10-8045 L001 S75W Application 20101124

**Wolli Creek Retail Development
S75W Modification Application
Rooftop Plant Mechanical Services Noise**

**Diagram 4 – Rooftop Plant**

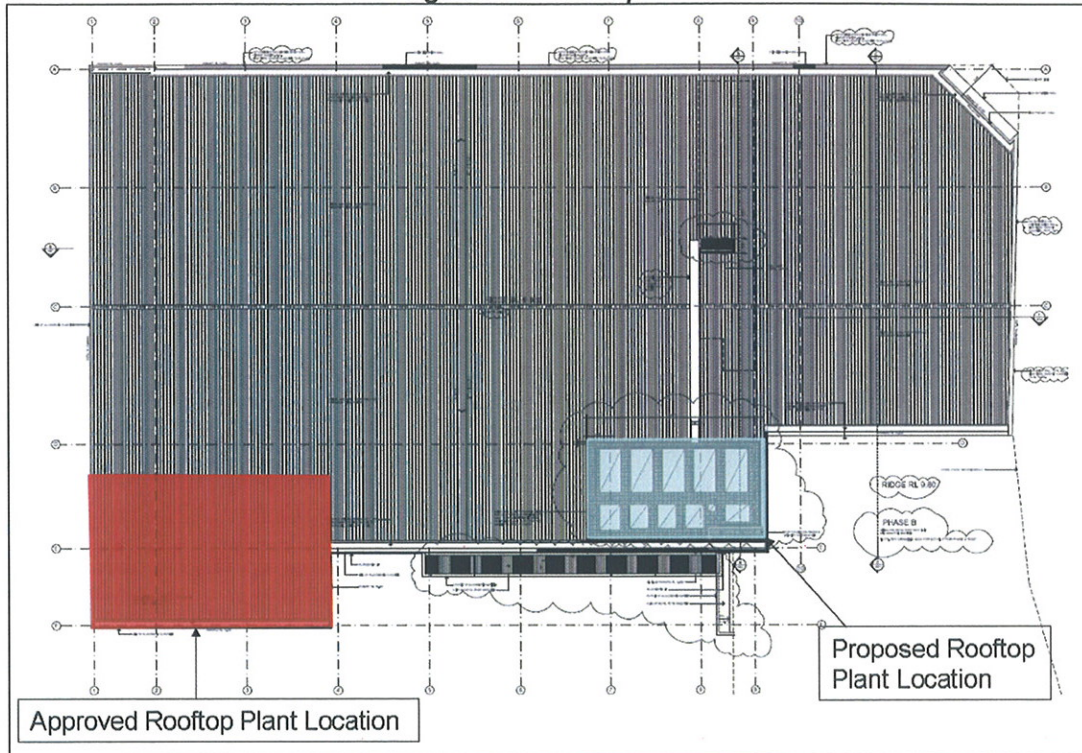
However, our review of the indicative plant suggests noise levels at the nearby residential towers may range from 44 dBA to 57 dBA, depending upon the number of items running and their operating mode (eg. part / full load etc). On this basis, there may therefore be occasions when compliance with the noise criterion of 50 dBA (as set out in our "Acoustic Assessment" report, 10-8045-R1, dated 24 September 2009) may not be achieved. (Where plant is to operate 24 hours a day, controlling the noise during the night period will be the over-riding condition, ensuring compliance at all other times.)

We therefore recommended that final equipment selection be reviewed during the detailed design stage to ensure compliance with the noise criteria at the affected residential receivers. This may require some noise control treatment such as enclosing the plant, or some thereof, or operational switching measures - or a combination of both.

We also recommended that the night-time criterion of 50 dBA should be reviewed during the design development stage to take into account potential shielding from the built environment, and any variation in ambient noise level that may occur with increased height up the residential towers.
